Our ref: DOC20/581552-8

### **Response to Submission comments for Lindfield Learning Village SSD 8114**

Thank you for your referral dated 17 July 2020 inviting comments from the Heritage Council of NSW on the Response to Submissions document for the above State Significant Development (SSD). It is noted that Heritage NSW is providing comments on Urbis responses to the Heritage Council Submission and Heritage Council Recommended Conditions of Consent dated 13 December 2019 in Appendix D, *Lindfield Learning Village Response to Submissions - Built Heritage*, prepared by Urbis Pty Ltd, dated 27 May 2020.

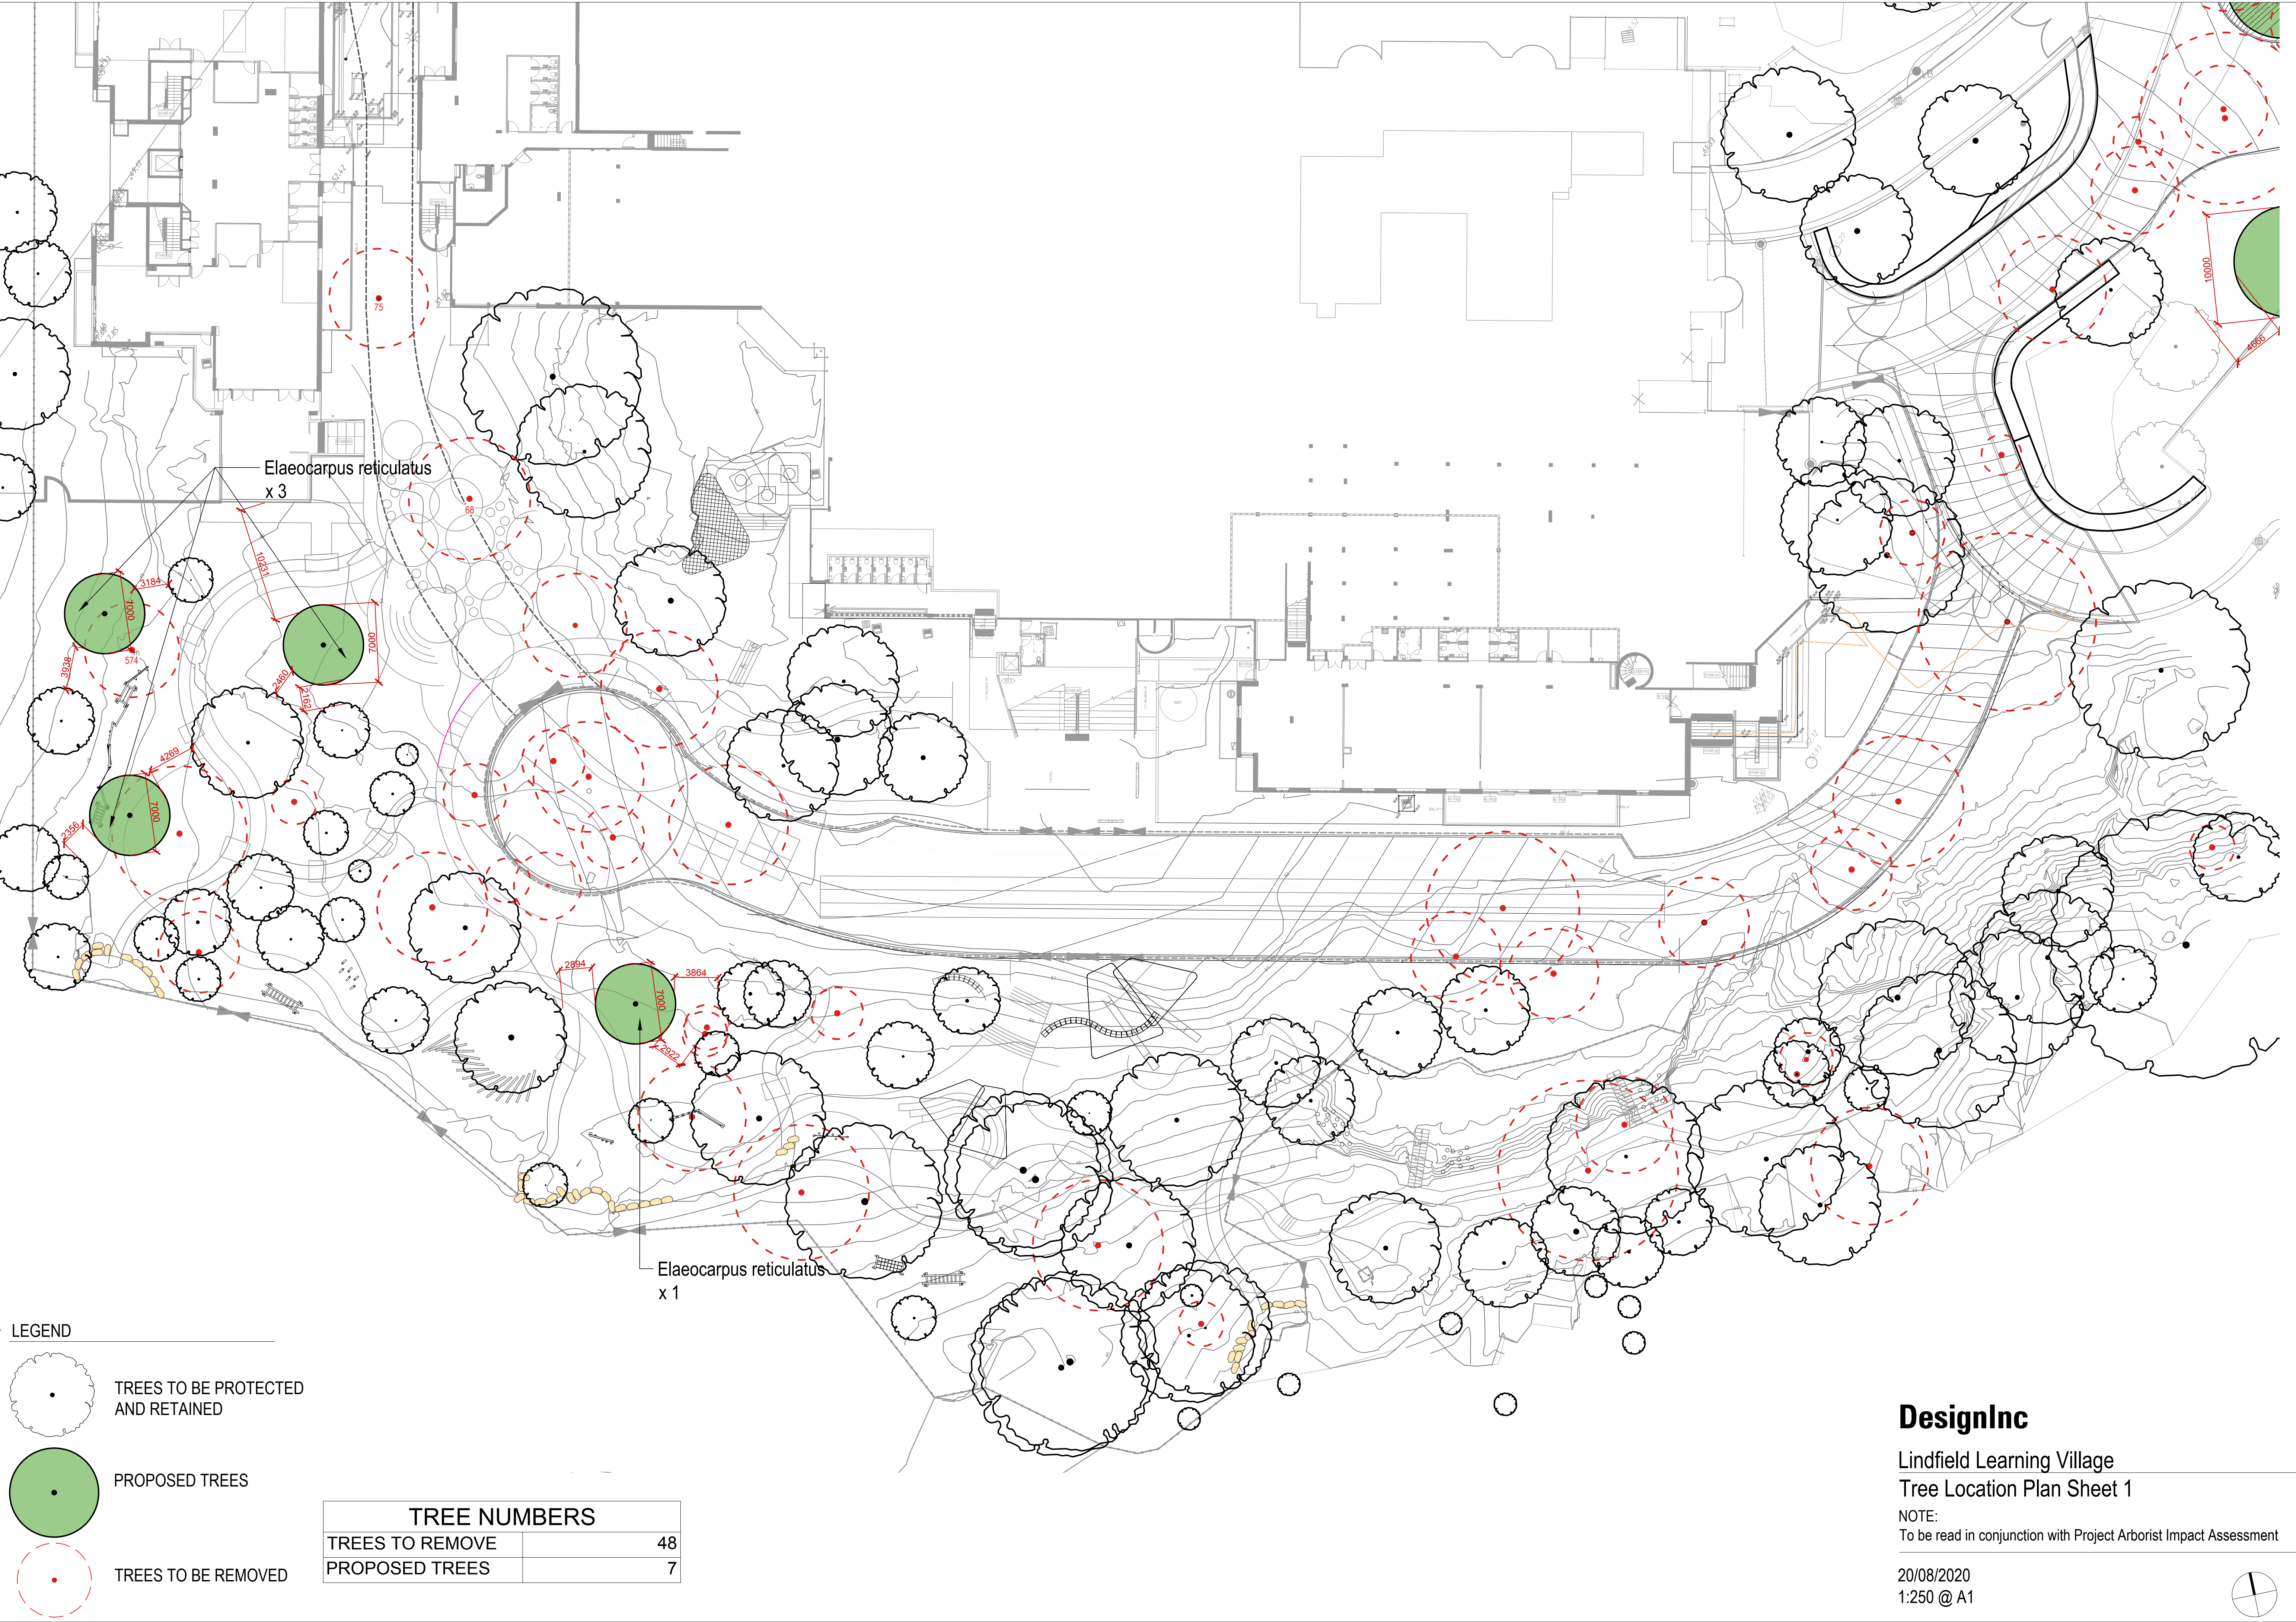
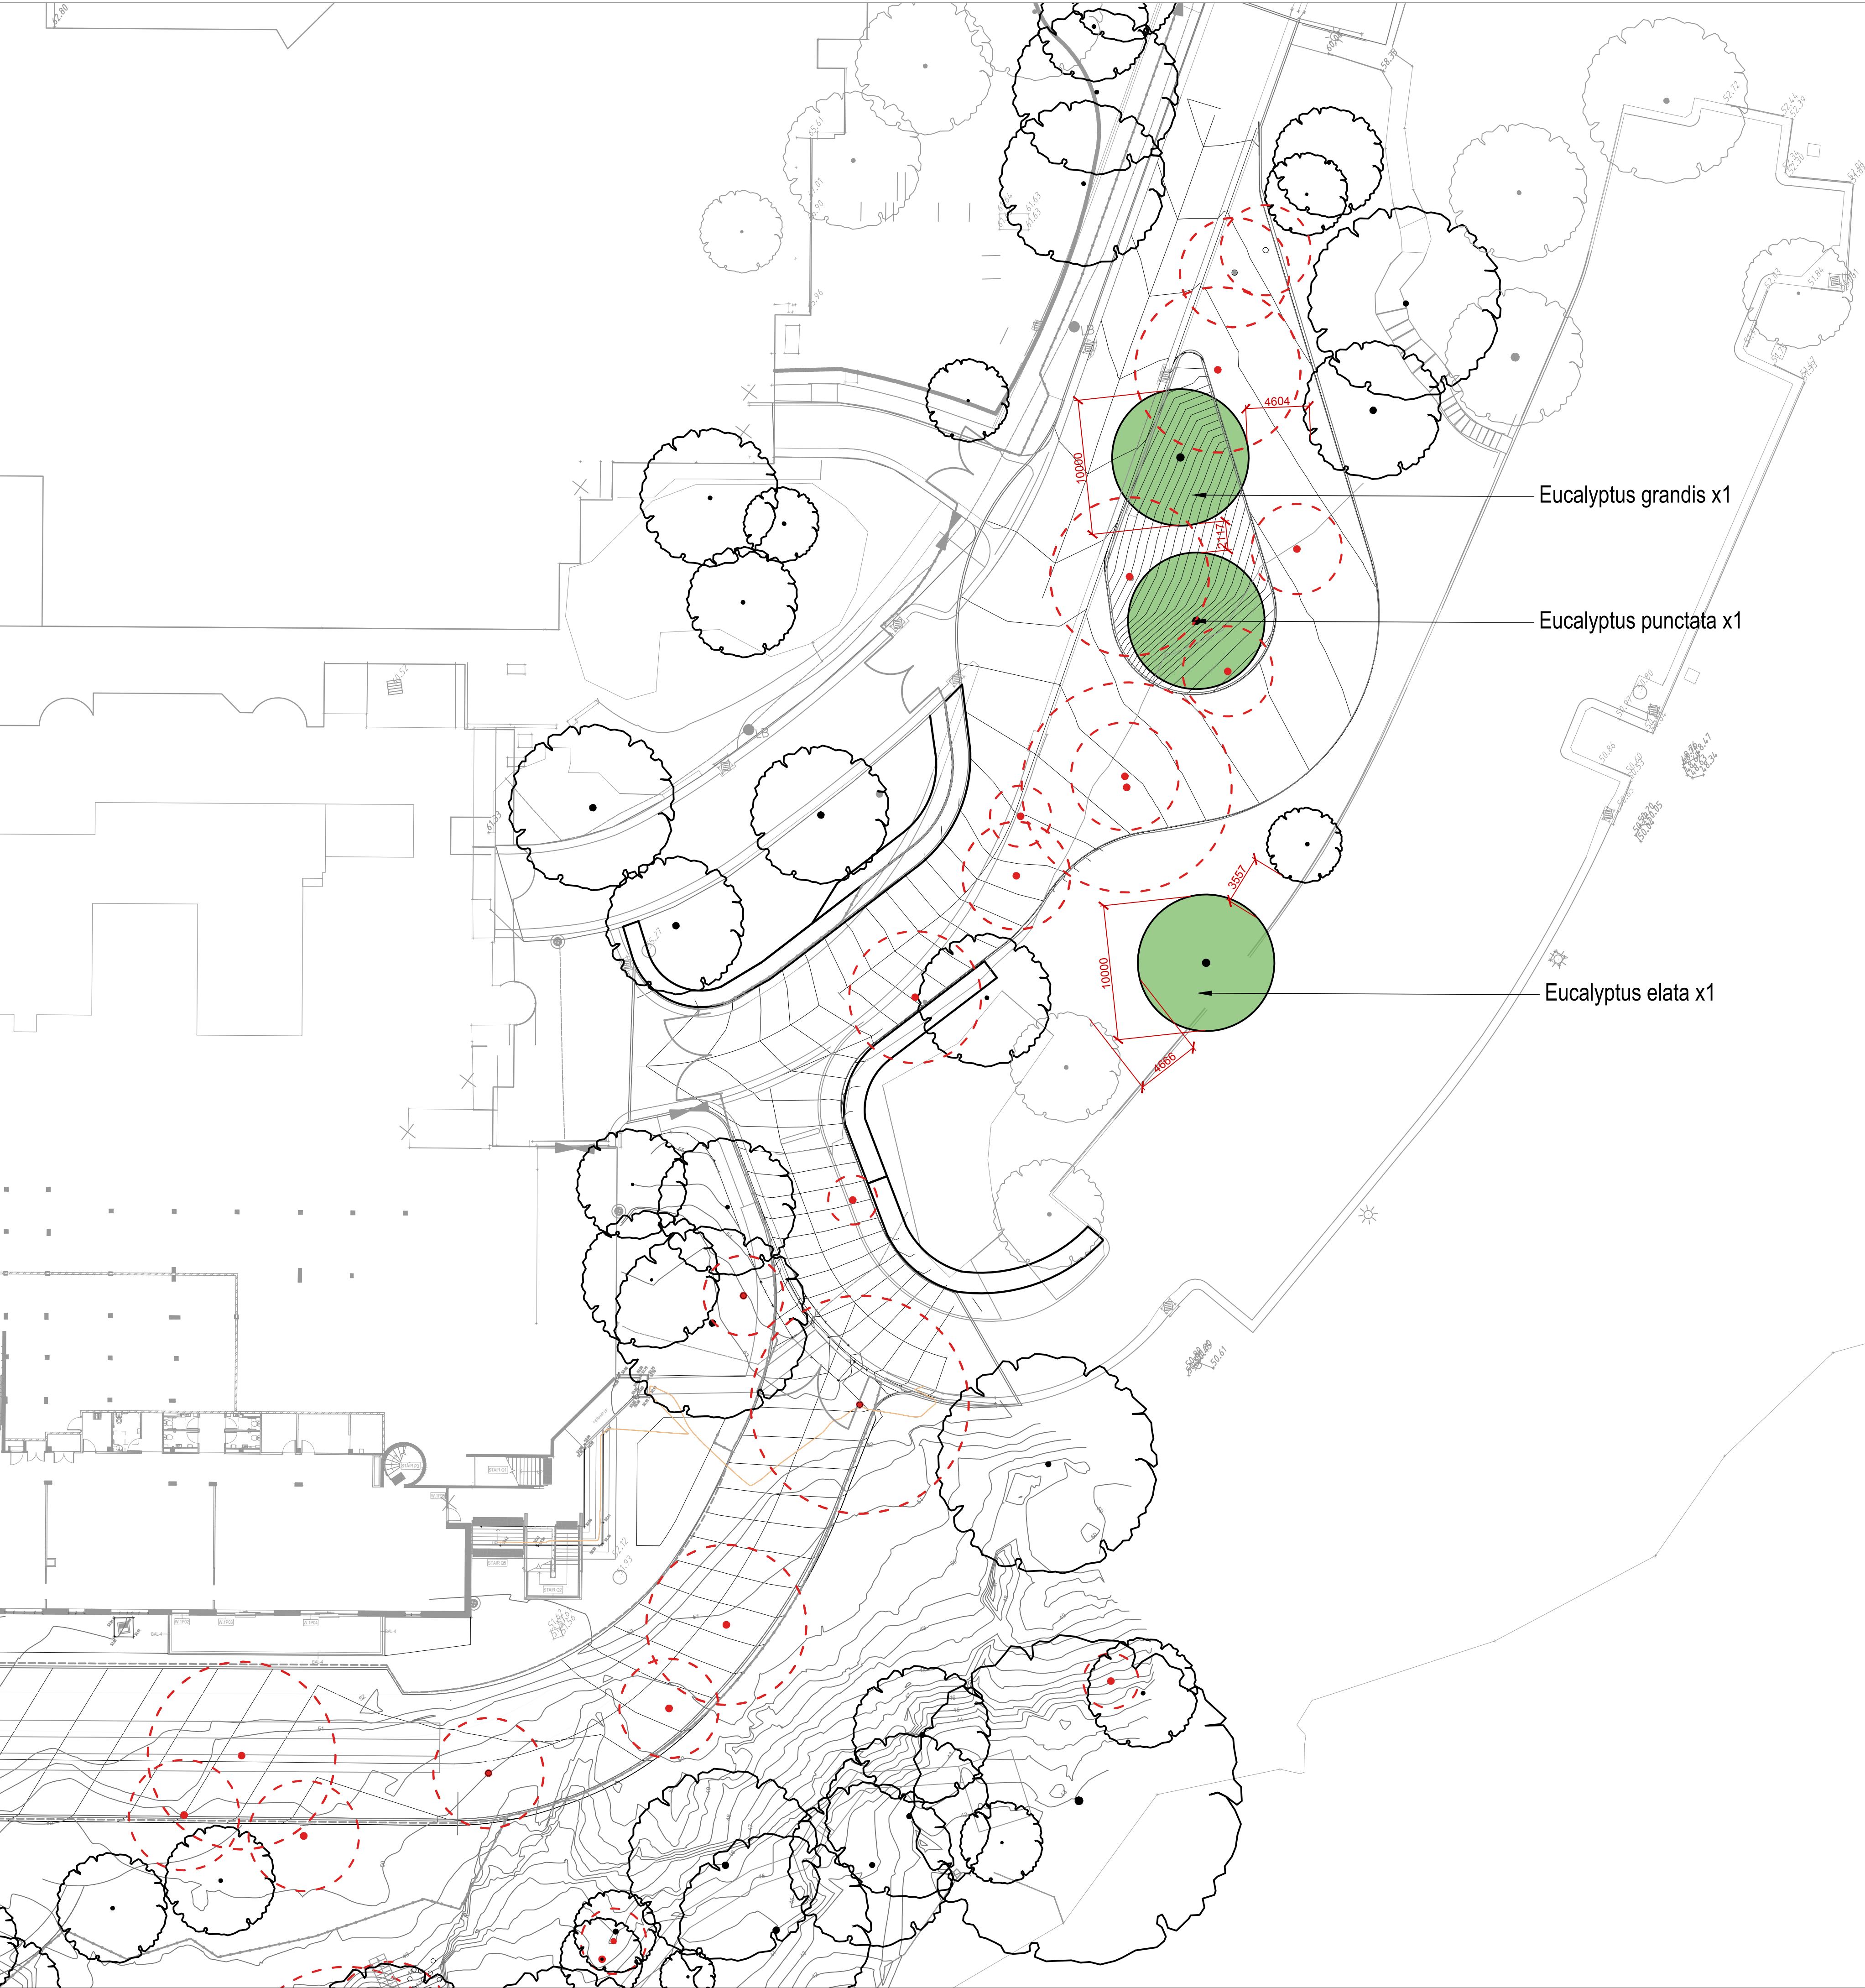
**HNSW comment:** Noted, however further investigation must be undertaken by the Applicant for replacement tree planting within the context of the landscape works at the site to mitigate the removal of the 26 trees associated with the Link Road, an additional 16 trees from the original proposal.
